RE: 100 Middle St. 2nd and 3rd floors

Subject: 100 Middle Street
2nd & 3rd Floor Tenant Fit-up
Building Permit # 05-1356

Station of Construction: 100 MIDDLE ST		Permit No: 05-1356	Date Applied For: 09/16/2005	CBL: 029 E026001
Business Name: Middle Street Management	Owner Name: MIDDLE STREET OFFICE TOWE 100 MIDDLE ST	Phone: 100 Middle Street Portland (207) 780-1680		
Lessee/Buyer's Name:	Contractor Name: Middle Street Management	Contractor Address: 100 Middle Street Portland (207) 780-1680		
	Phone:	Permit Type: Alterations - Commercial

Commercial/ Office tenant fit-up 2nd & 3rd floors

**PARTIAL 3RD FLOOR FRAMING PLAN**  
1/4"=1'-0"

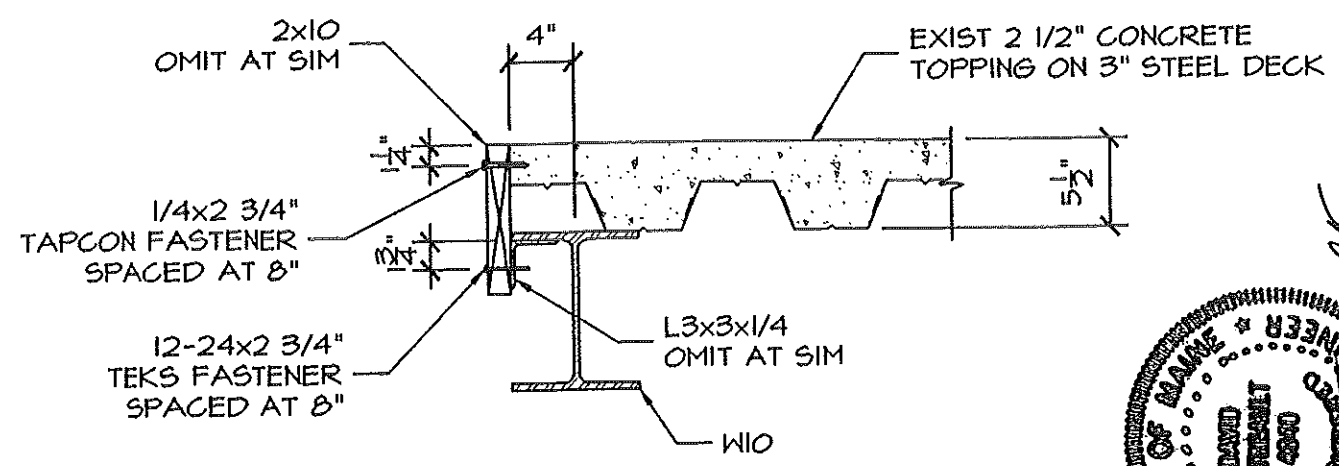
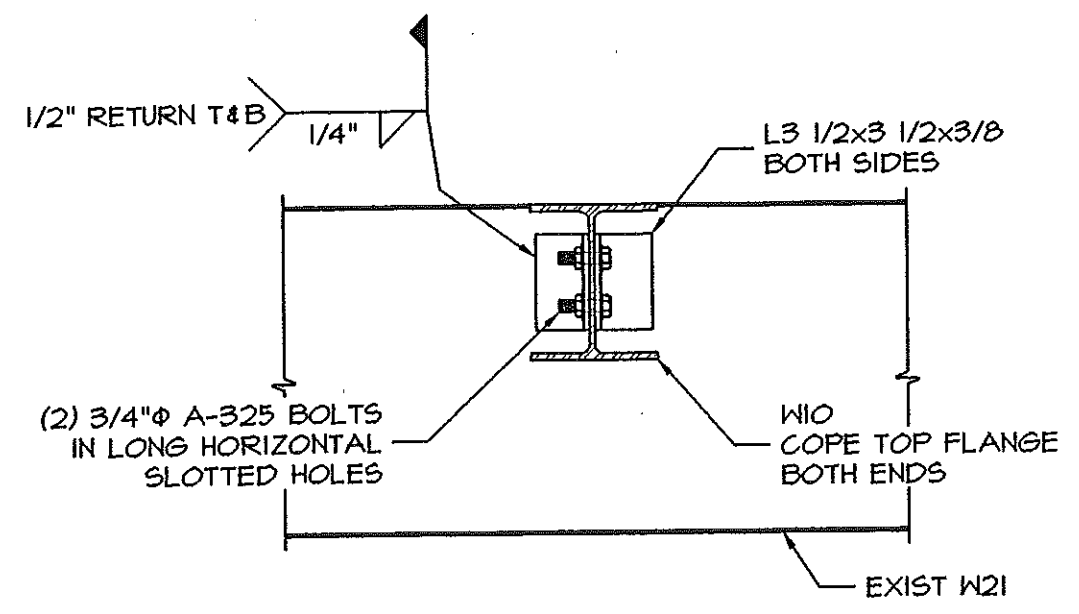
- 1) Prior to fabrication or installation of the interior communicating, non-egress stairway, the architect must submit plans for, and obtain approval for either a non combustible stairway pan or a stairway w/ Flame retardent treated wood stringers and Light gauge steel landings, all elements enclosed in fire rated construction. The treads and other trim can be of acceptable combustible materials. See Section 603 of the 2003 IBC.

- 10/17/2005-rmjn: Need plan for proposed connecting stairway as well as Framing detail for walls. Left message w/ applicant and architect.
- 10/19/2005-rmjn: Architect dropped off stir plans...don't meet code, advised the fabricator, also still need Structural for the new stair opening.

Our structural engineer has provided a non-combustible assembly for the stair landing utilizing light gauge metal studs and fire-retardant plywood decking.

ALL FRAMING IS LIGHTGAGE STEEL BY DIETRICH INDUSTRIES OR APPROVED ALTERNATE. LANDING DECK IS 3/4" FIRE-RETARDANT TREATED (FRT) PLYWOOD.
